single storey rear extension.
new second floor dormer roof to provide master bedroom suite.
alterations to front elevation, including replacement garage, porch to front door, new
slate roof finish, raised roof eaves to provide enlarged first floor and rendered and
horizontal weatherboarding to front and rear elevations.

Blakeney Cottage Sylvan Way Bognor Regis

Thank you for your internet representation made on 13th December 2018 which has been recorded as '**an objection**' with the comments as follows:

**PROPOSED
ELEVATIONS**

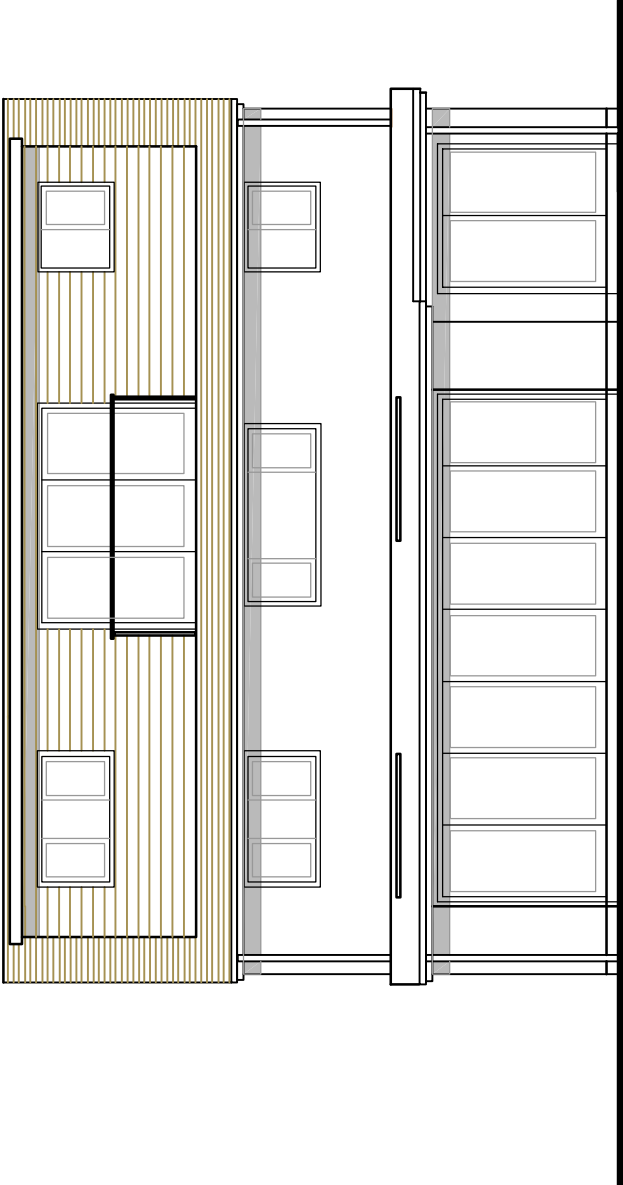
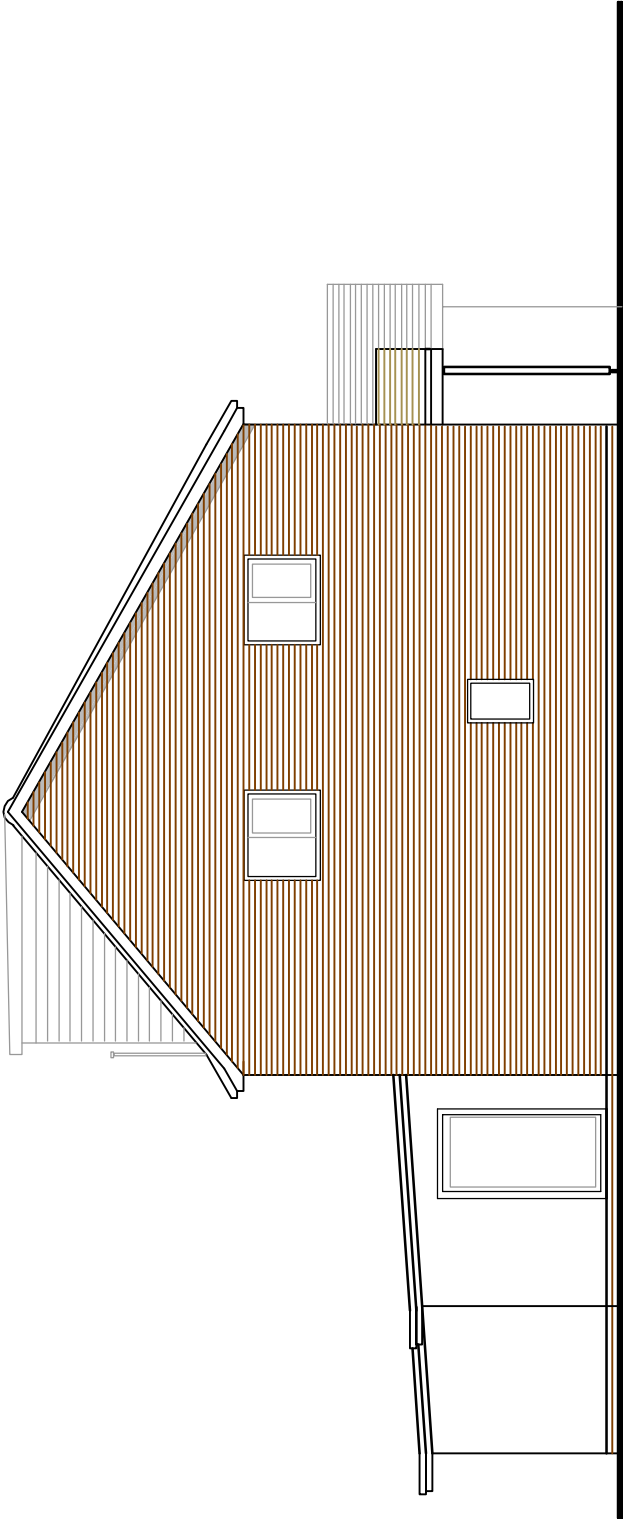
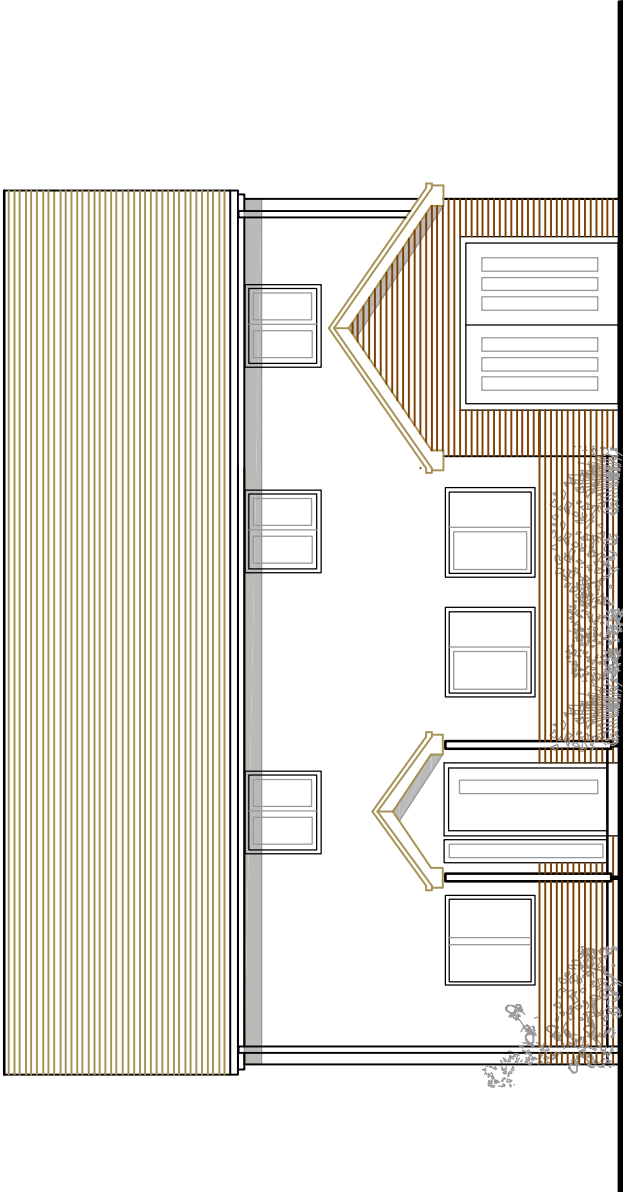
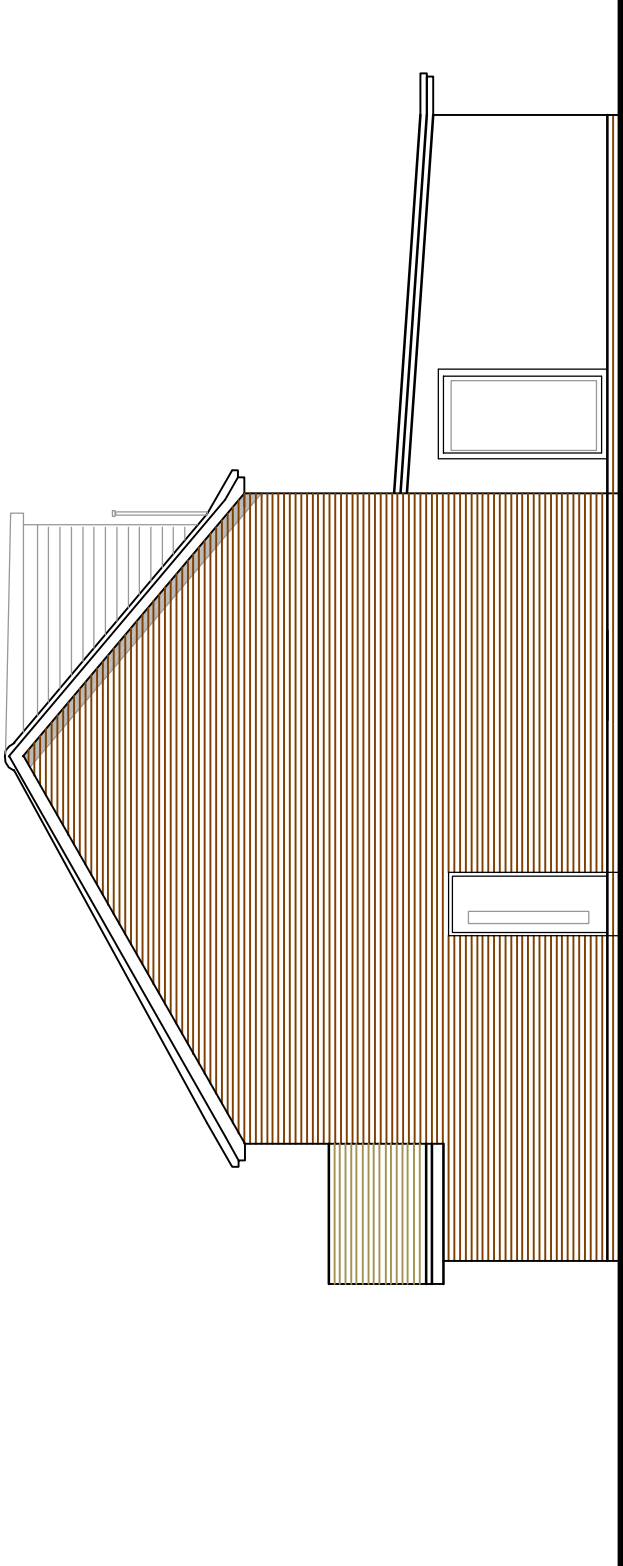
The slate roof proposed seems as though it will be completely different from the adjoining properties and the horizontal weatherboarding is out of tune with the brick and part tile hung appearance of the existing properties.

I do not know how much the height will be increased by, but it seems likely that the changed building will dwarf the bungalow next door.
